## LETTER OF TRANSMITTAL

**Niederman Residence**

**Critical Area Determination CA017-001 First Review Letter – RESPONSE LETTER**

In response to your First Review Letter, dated May 3, 2017, kindly accept this letter and all referenced attachments as my formal response on behalf of our clients, Nicole & Chris Niederman. I trust that with this info in hand, you'll find that we're in compliance with the zoning code, Title 19 of Mercer Island City Code (MICC) for our proposed land use application. In direct response to your notes, please find my numerated response below.

REFERENCE SHEET NO. **Q2**

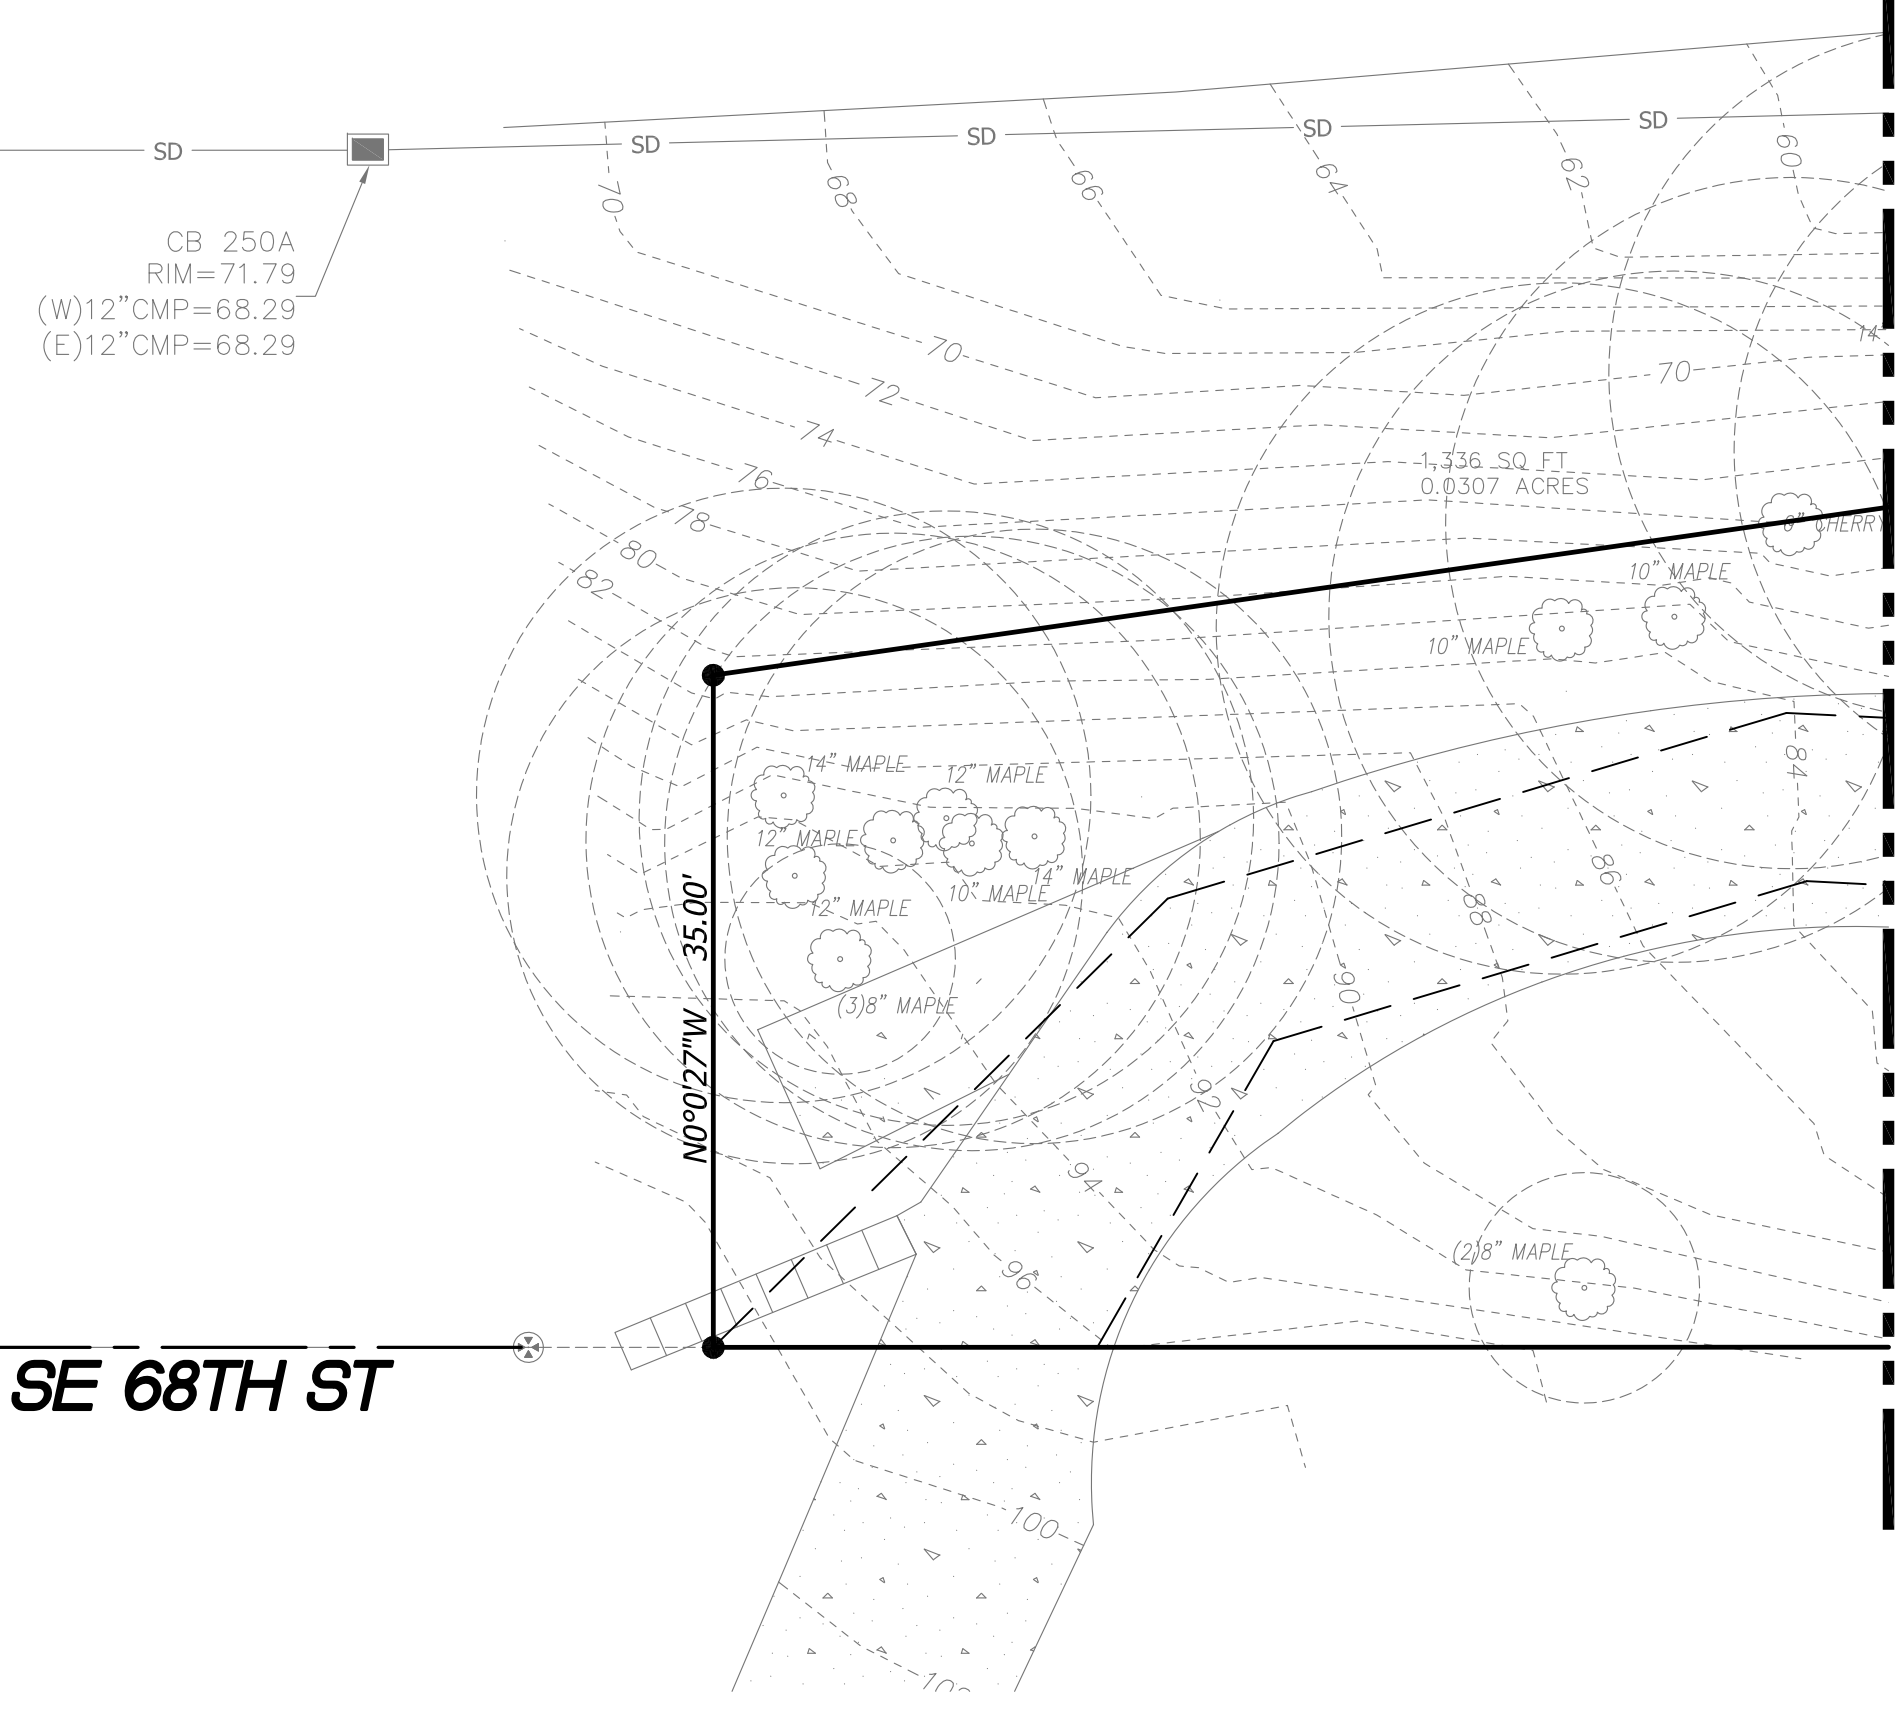
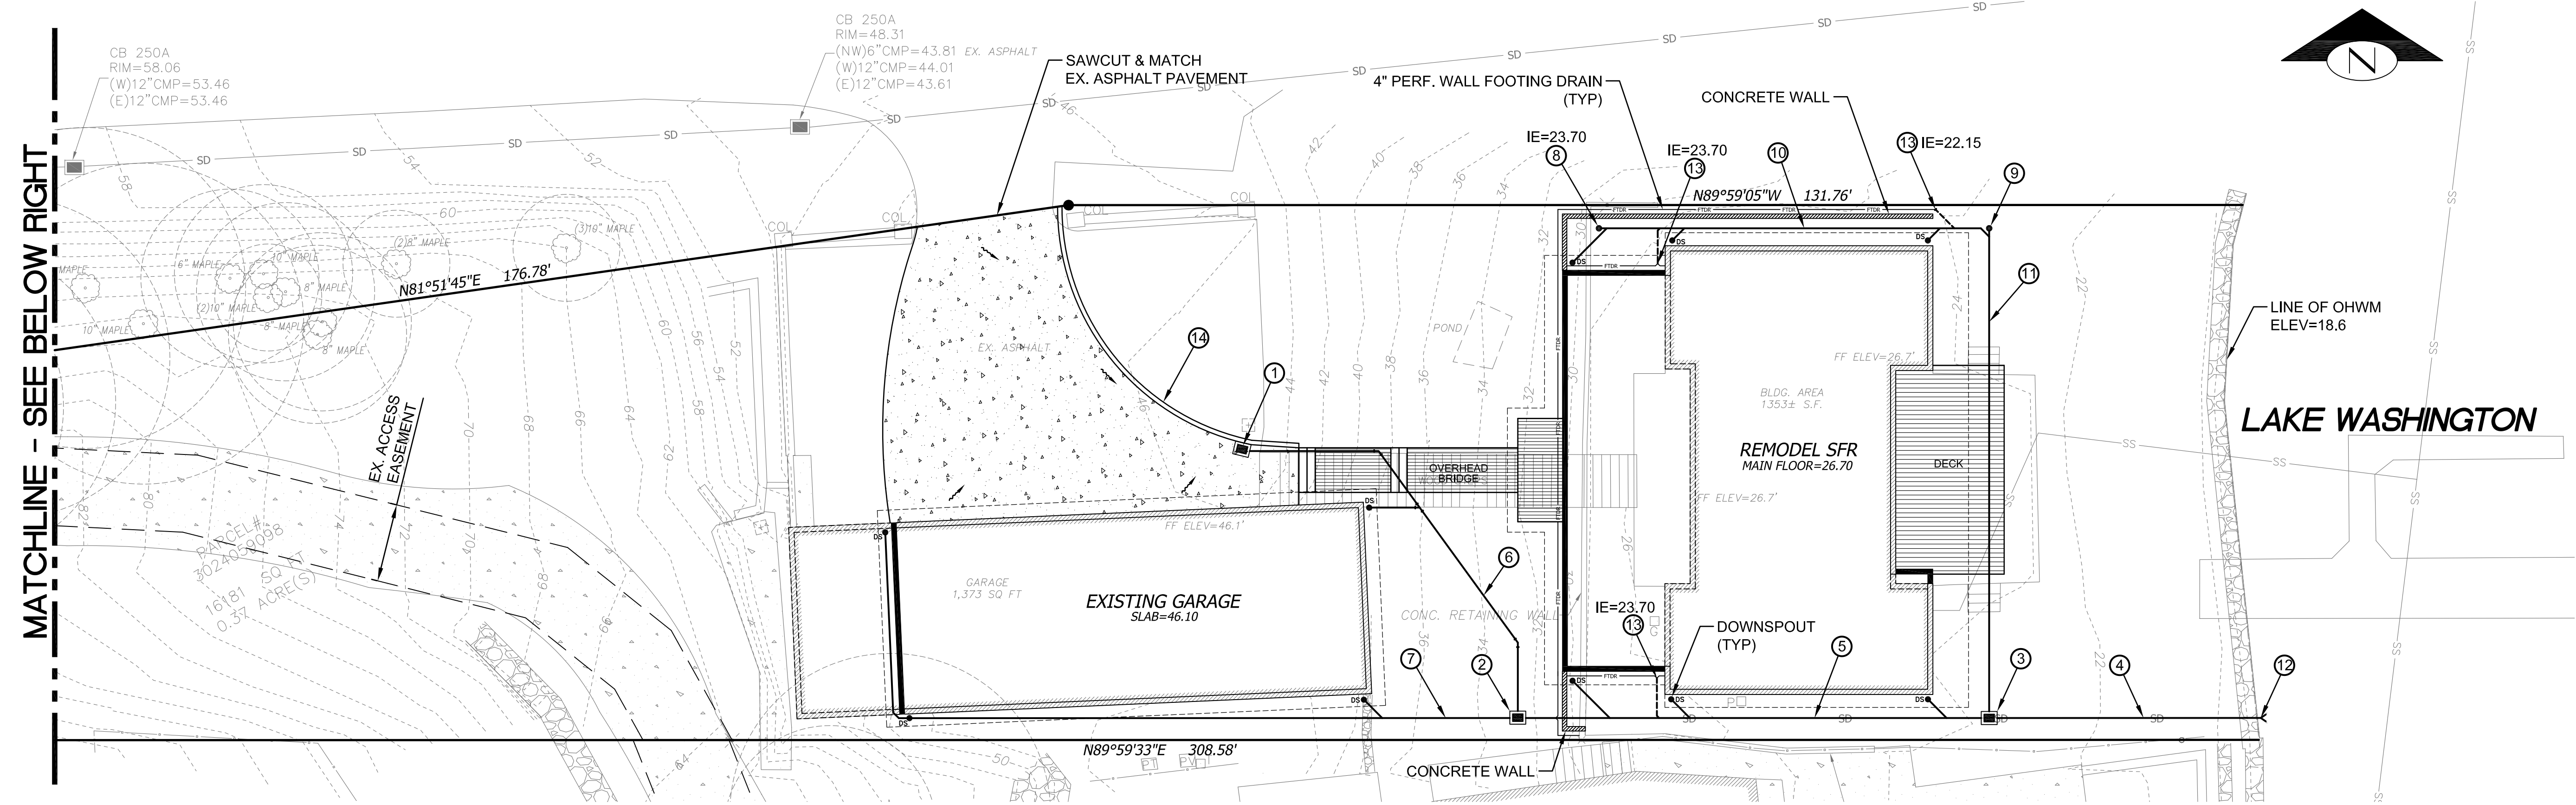
2. *Please provide a stormwater management plan associated with Site Development.*

- iii. The existing piped watercourse is limited to capturing runoff from the private driveway not to mitigate additional or change in runoff.

- Attached, PBG's C1. TESC Plan & Details
- Attached, PBG's C2. Stormwater / Utility Plan & Details

- Per attached TESC & Stormwater Plans, runoff will be managed appropriately & separately from the piped watercourse.
